### City of Gosford Design Advisory Panel

Review item: Exhibition of State Significant Development Application – Gosford Alive (SSD-9813)

The City of Gosford Design Advisory Panel has reviewed your revised proposal for Gosford Alive at 136-148 Donnison Street, Gosford (former Market Town/Kibbleplex). A summary of the Panel's observations, advice and recommendations arising from the review is attached to this letter (**Attachment A**).

Project Number
218155

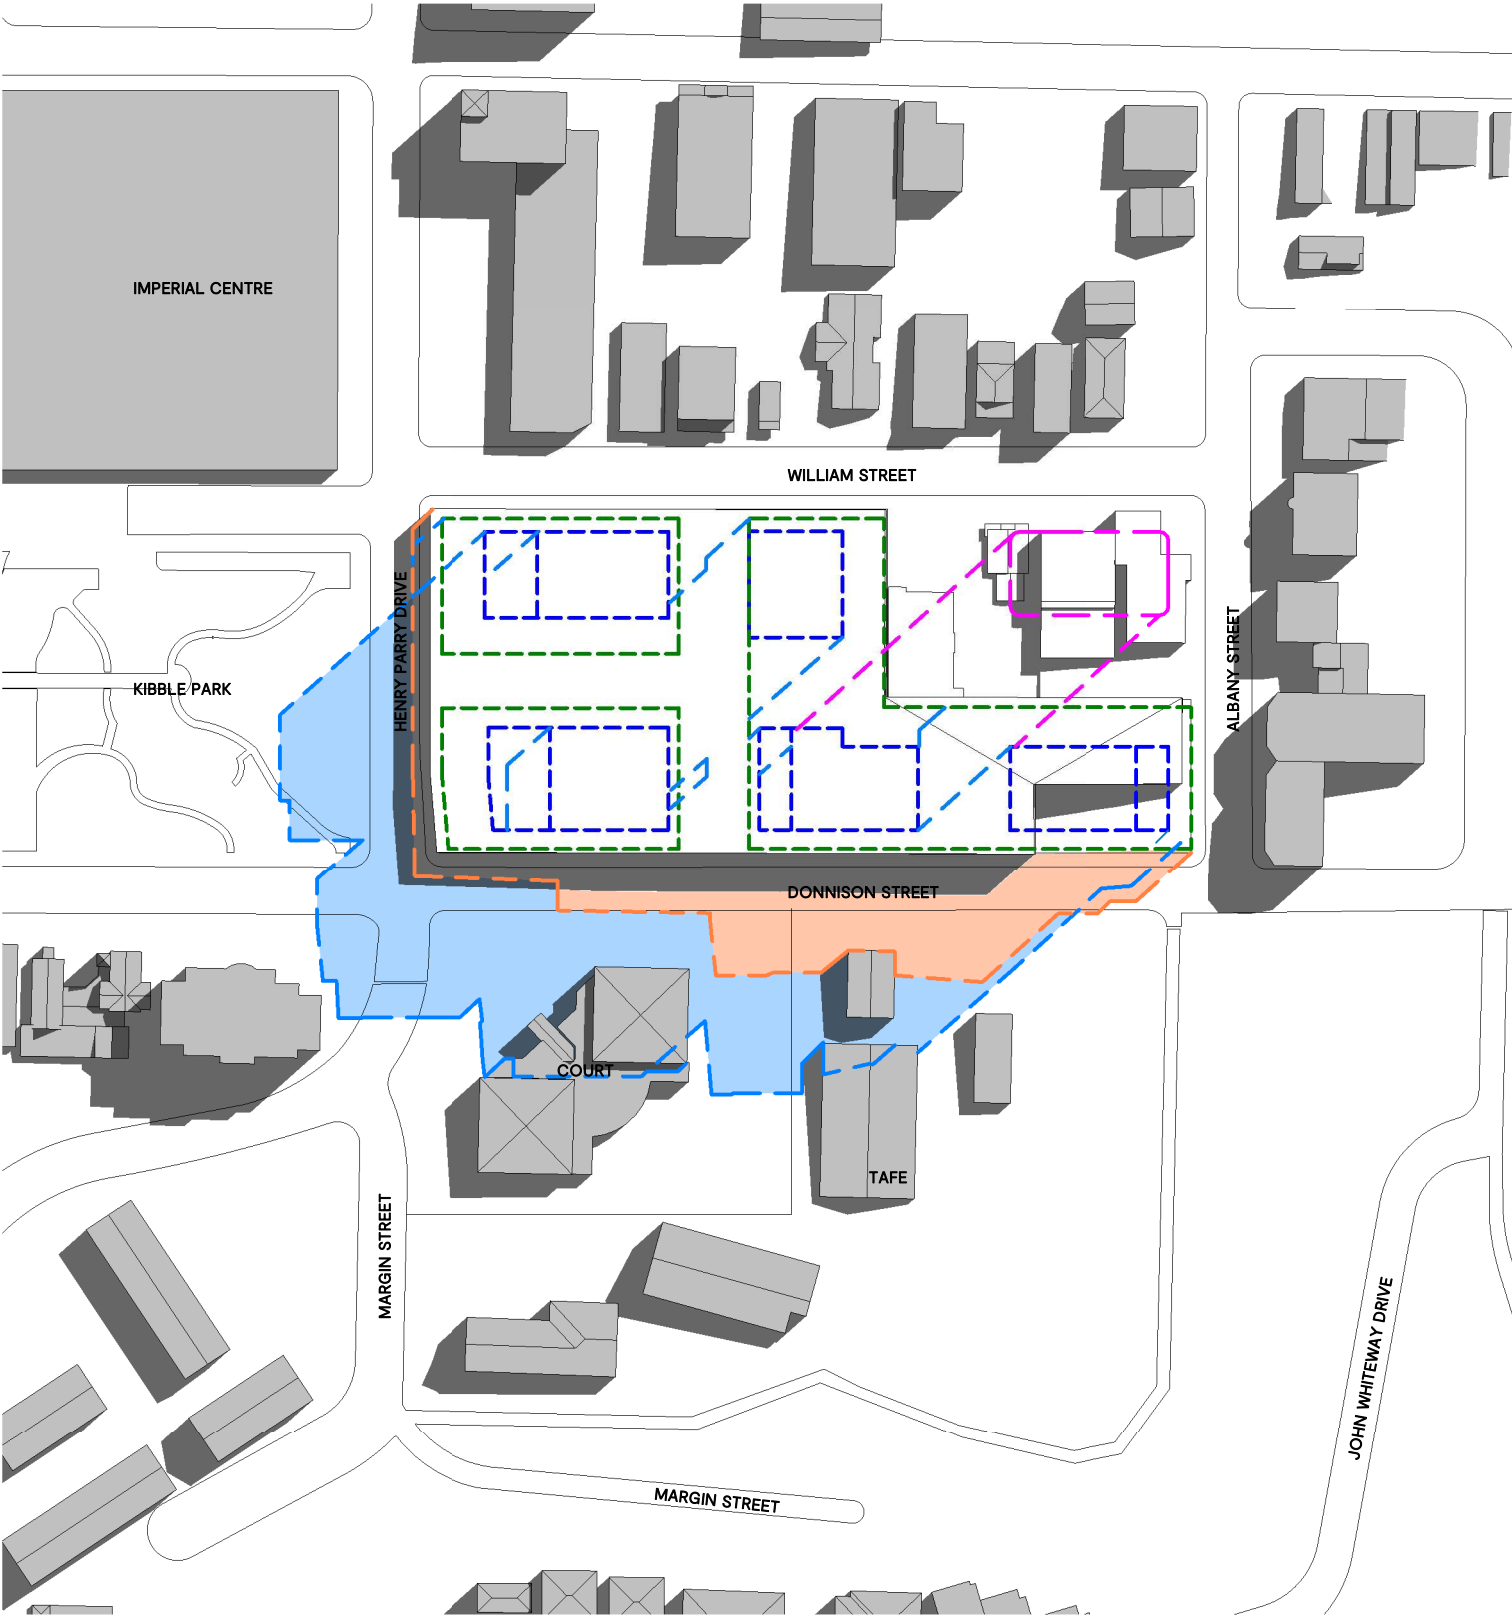
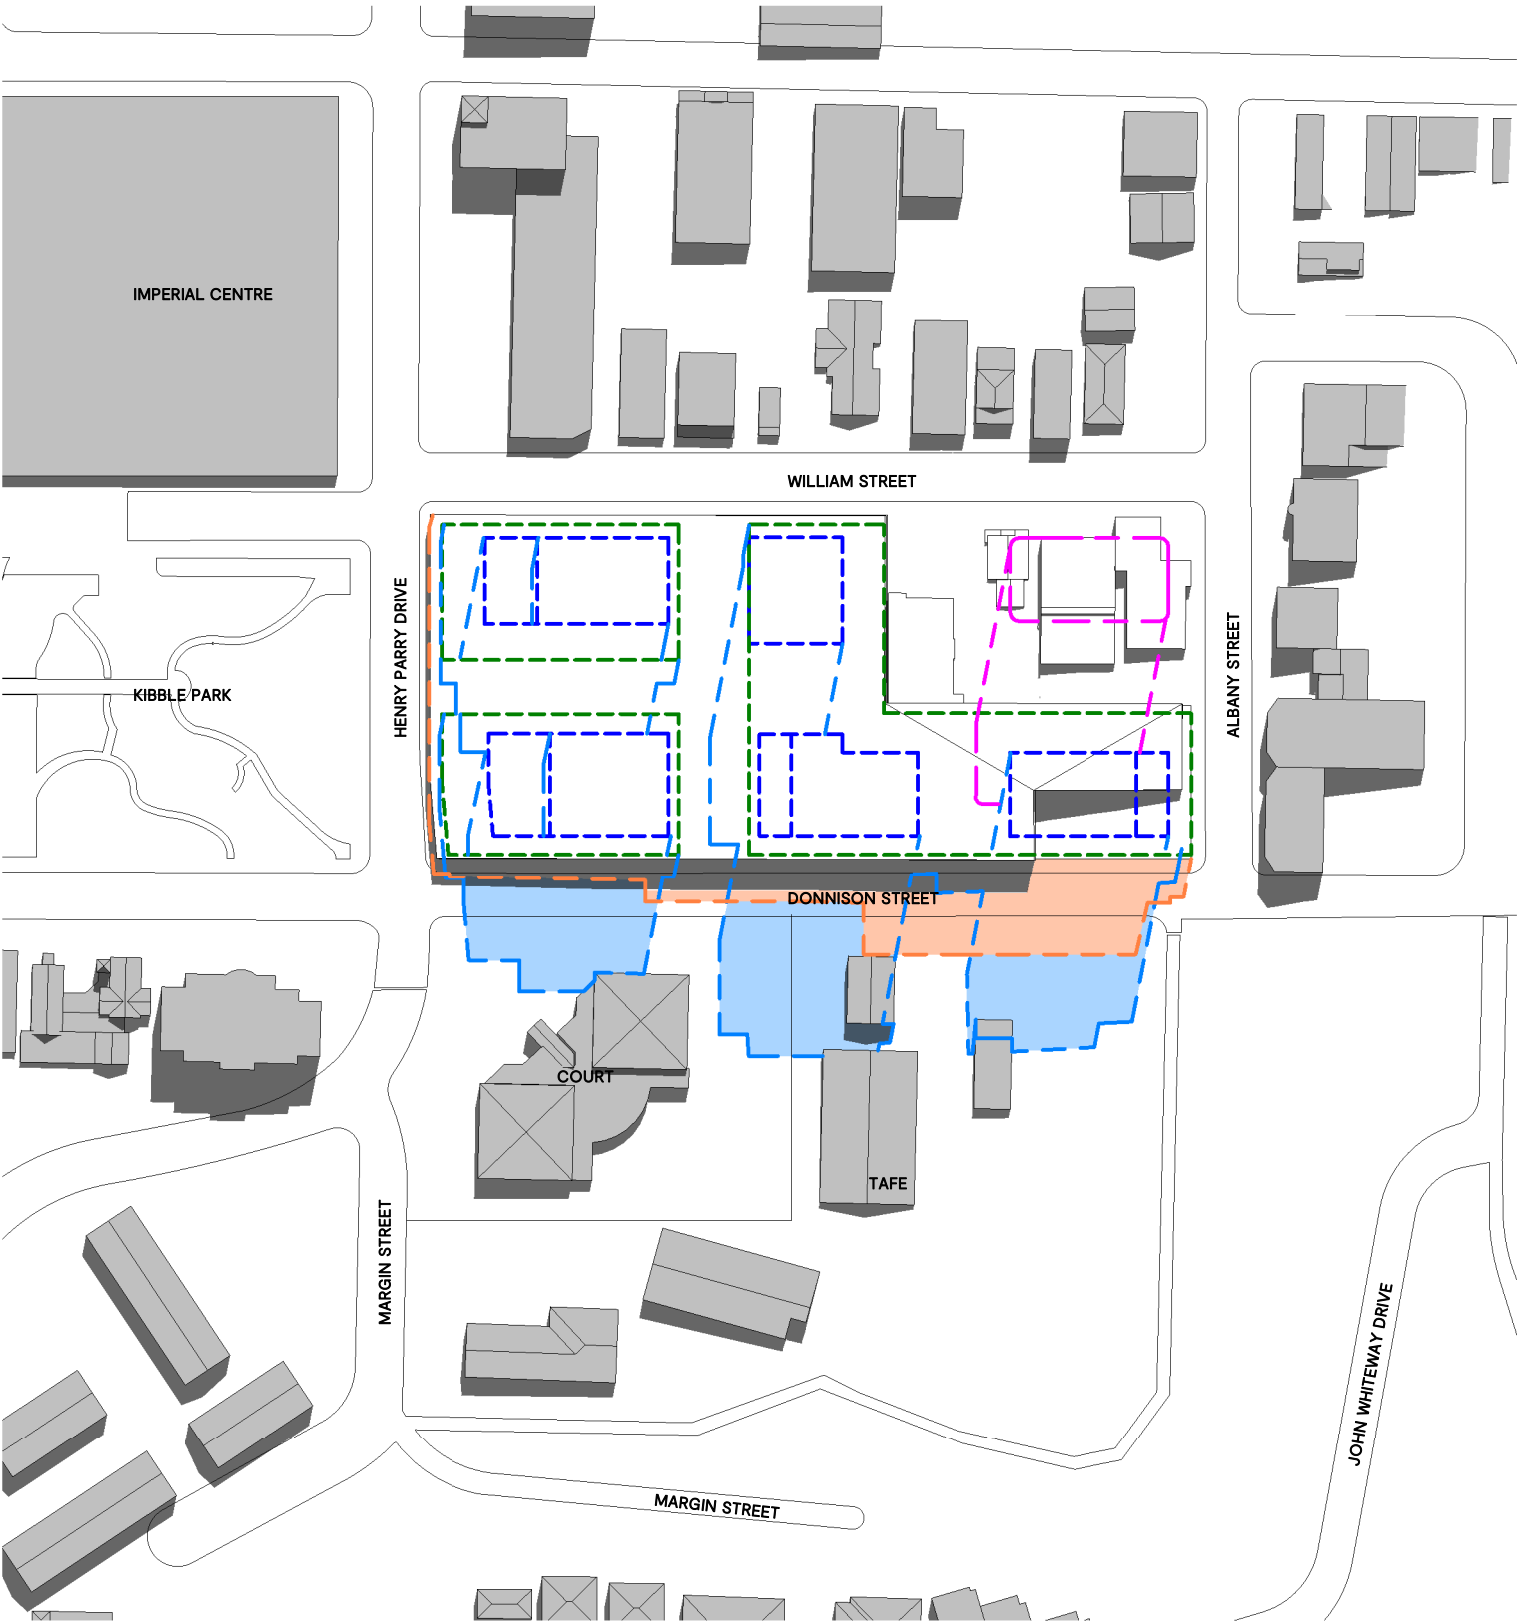
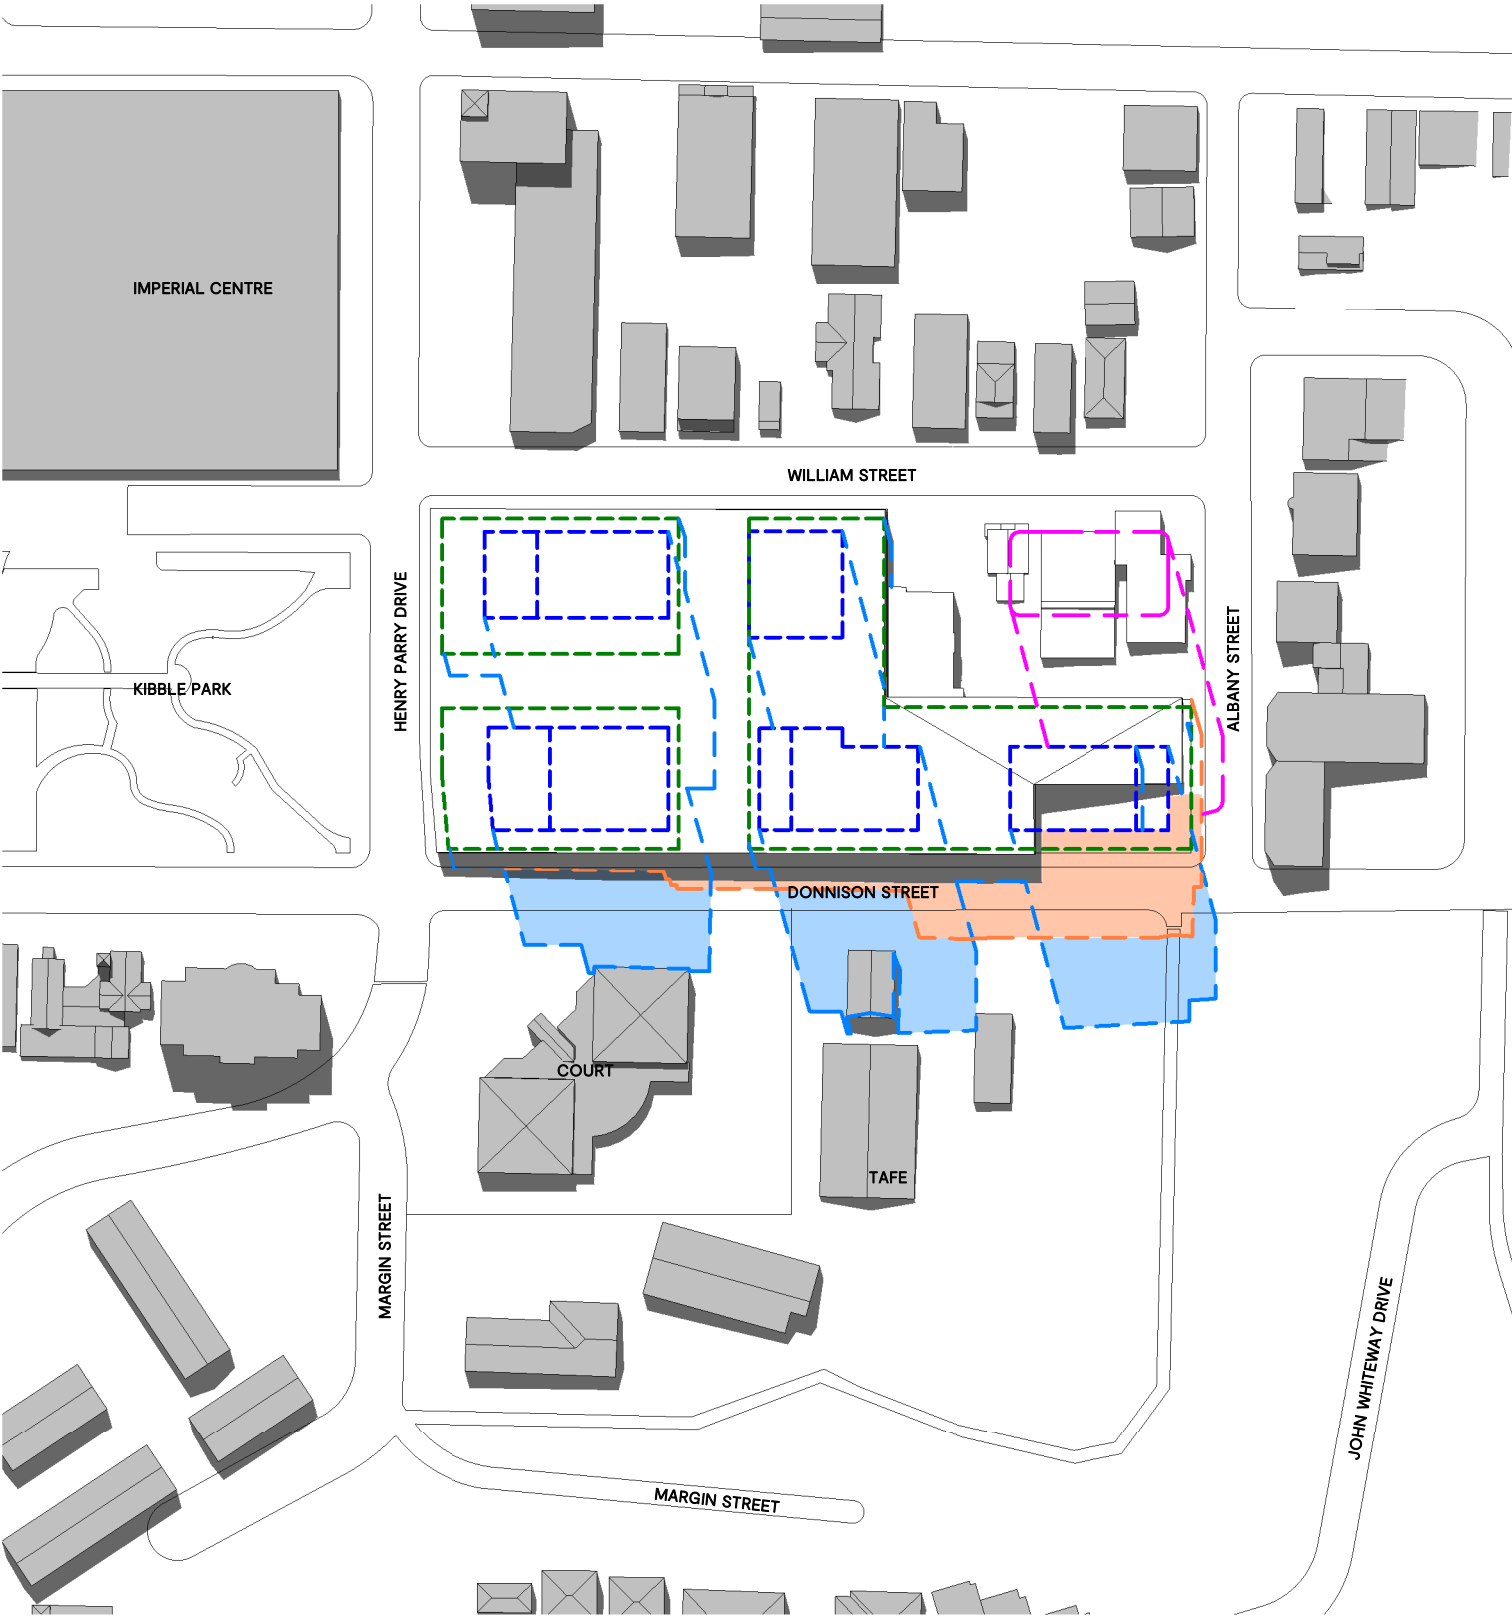
The Panel was not able to determine whether all future apartments will achieve the ADG solar access requirements for the proposed southern towers. The solar study should be updated to include the view from the sun and any shadow impacts on the proposed envelopes to allow it to be considered as part of the current assessment process. The Design Guidelines to ensure that future apartments in the development achieve, as a minimum, ADG compliance, noting the Panel's view that the proposed tower envelopes, from an urban design perspective, are acceptable.
